Make a Planning Appeal

WEBLRD6093/26-S3B

MILLTOWN PARK, SANDFORD ROAD,
DUBLIN 6,
Dublin
D06 V9K7
Ireland

Third Party planning appeal in respect of the decision of Dublin City Council to issue Notification of Intention to Grant Planning Permission, under planning application, reg. ref. WEBLRD6093/26-S3B, for proposed development comprising of: "... a large-scale residential development ... The development will principally consist of: "the demolition of c. 4,847.5 sq m of existing structures on site including Milltown Park House (880 sq m), Milltown Park House Rear Extension (2,031 sq m), the Finlay Wing (622 sq m), the Archive (1,240 sq m) and the Link Building between Tabor House and Milltown Park House Rear Extension to the front of the Chapel (74.5 sq m); the refurbishment and reuse of Tabor House (1,575 sq m) and the Chapel (768 sq m) and the provision of a single storey glass entrance lobby to the front and side of the Chapel (52 sq m); and the provision of 562 No. residential units comprising 6 No. three-bed courtyard houses and 556 No. apartment units (70 No. studios, 176 No. one-bed units, 267 No. two-bed units and 43 No. three-bed units). Block A1 will range in height fr

Figure 3.8: Separation Distances Proposed with Large Setbacks from Block C and 2 No. Storey Courtyard Houses in Block E Highlighted

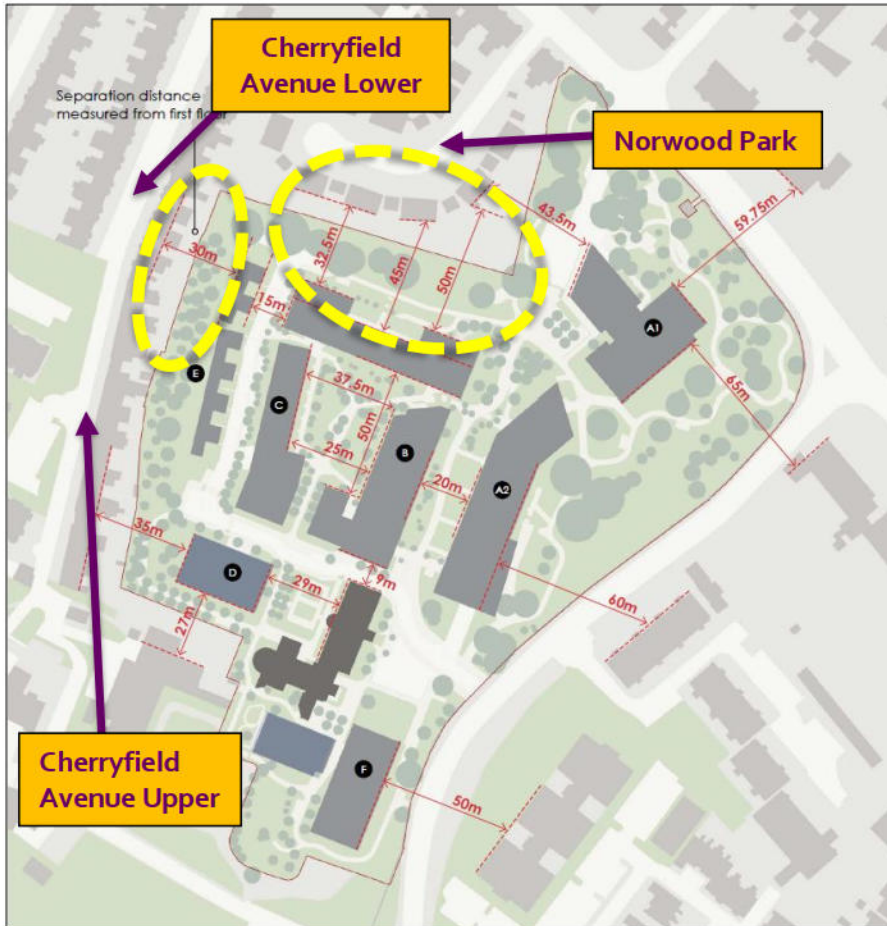
Block C should be 1,2, 3, 4 storeys, preferably not 5 storeys, and the 6th and 7th storeys are unacceptable. The taller storeys contain west facing windows and balconies which would adversely overlook our client's residents' Z2 zoned homes and area.

The attached Planning Objection report has confirmed the adverse impacts Block E would have on the established residential and visual amenities of our client's residents' properties. The report has also shown how Block E's removal from the scheme would improve the scheme. The Commission has already removed part of Block E in the SHD decision as it was unacceptable – it is not clear how the rest of Block E is any more acceptable than the removed part (now retained by the applicant). Block E needs to be removed to allow trees and open space to be sited in its place which offer screening to Cherryfield Avenue Lower and Upper.

If ACP wishes to retain Block E then given concerns over the duplex units having poor amenity views to the rear and so on, why not remove the first floor entirely and all overlooking terraces. This would reduce the adverse impacts arising for our client's residents.

Block D should be reduced to 2 storeys as it adjoins Cherryfield Avenue Upper and it should be setback to allow a landscaped tree-filled corridor to be provided along the western boundary. The taller section should be 3 storeys.

Figure 3.27: Boundary Treatment Strategy

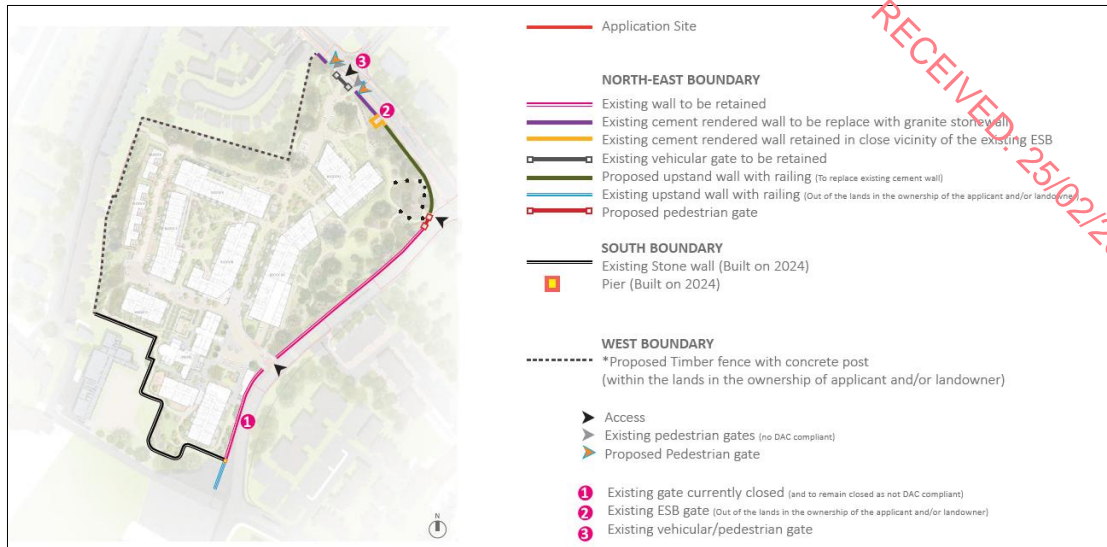
There is a need to offer landscaped, and tree-filled screening of the scheme from adjoining properties to the west at Cherryfield Avenue Upper. The proposed 1.8m tall boundary treatment is not going to provide any screening. This would offer our client's residents some better distribution of open space to the west of the site.

In the interests of fairness, balance, the protection of residential amenities, and the mitigation of the adverse impacts of this scheme on our client's residents, there is a need to offer landscaped, and tree-filled screening of the scheme from adjoining properties to the west at Cherryfield Avenue Upper. The proposed 1.8m tall boundary treatment is not going to provide any screening.
